LORSON RANCH EAST FILING NO. 1
FULL SPECTRUM POND D2
OUTLET STRUCTURE

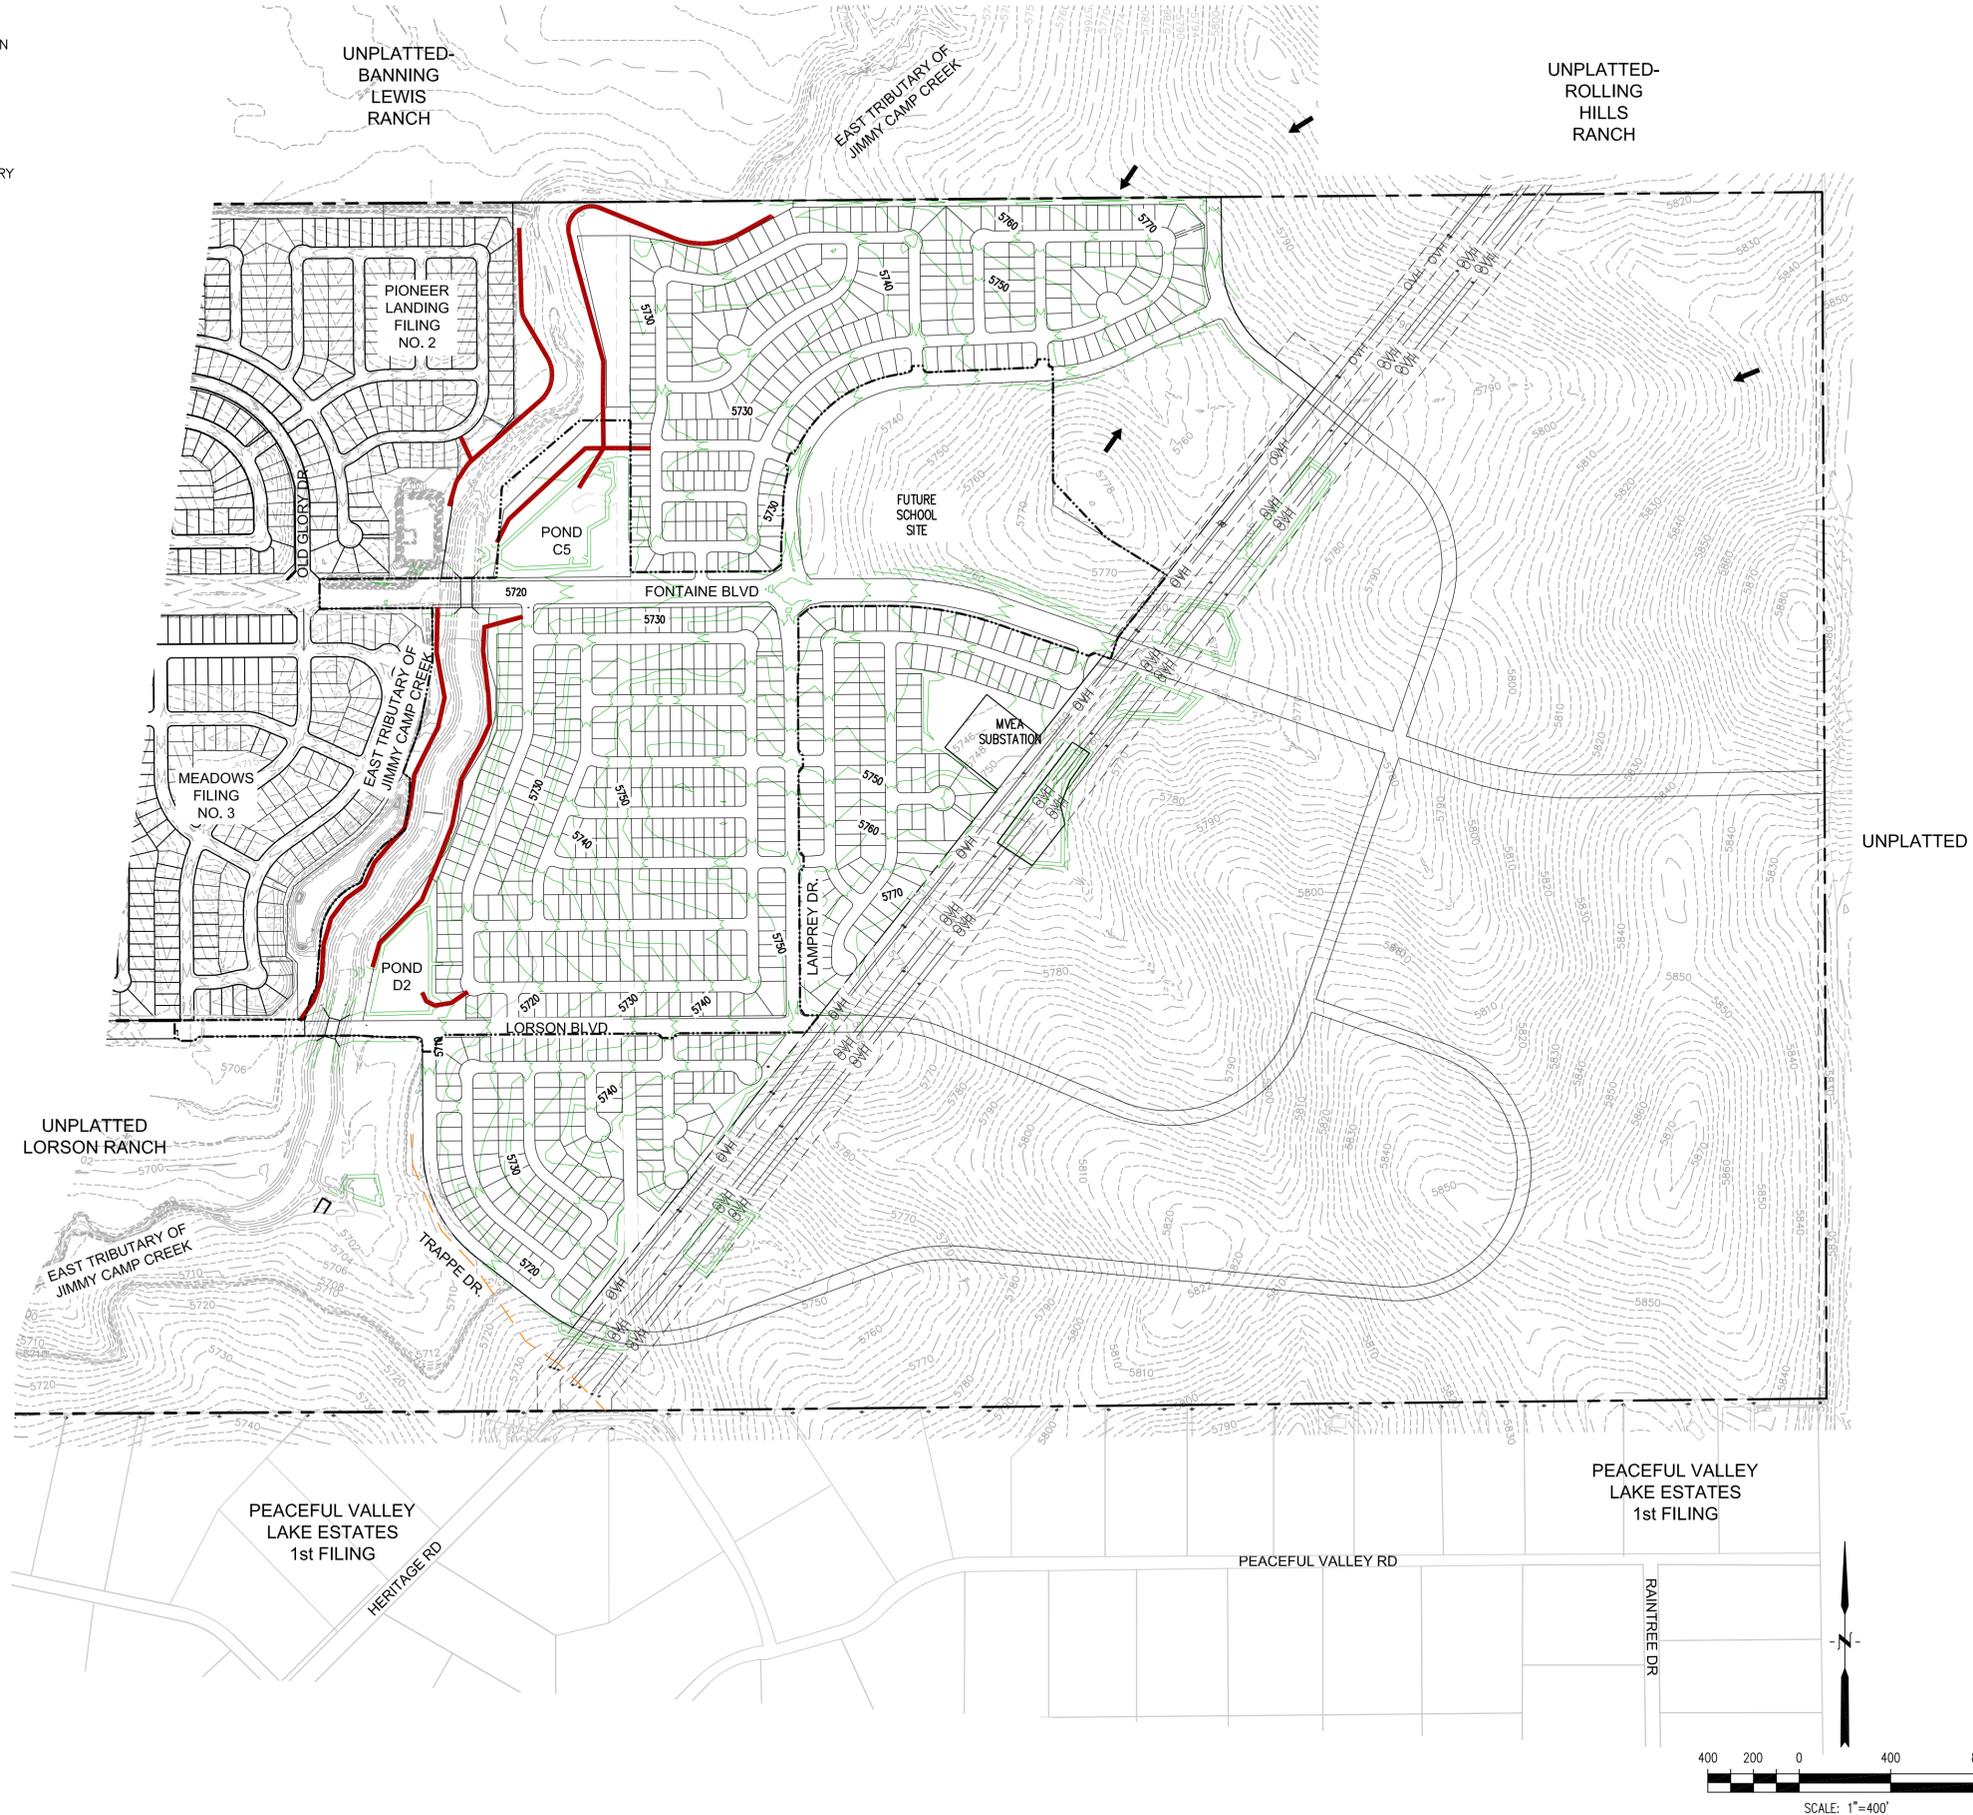
These velocities should be <2 for safety reasons.
Reference UDFCD Volume 2 11.5.3.

grate open area should be 4x outlet pipe open
area
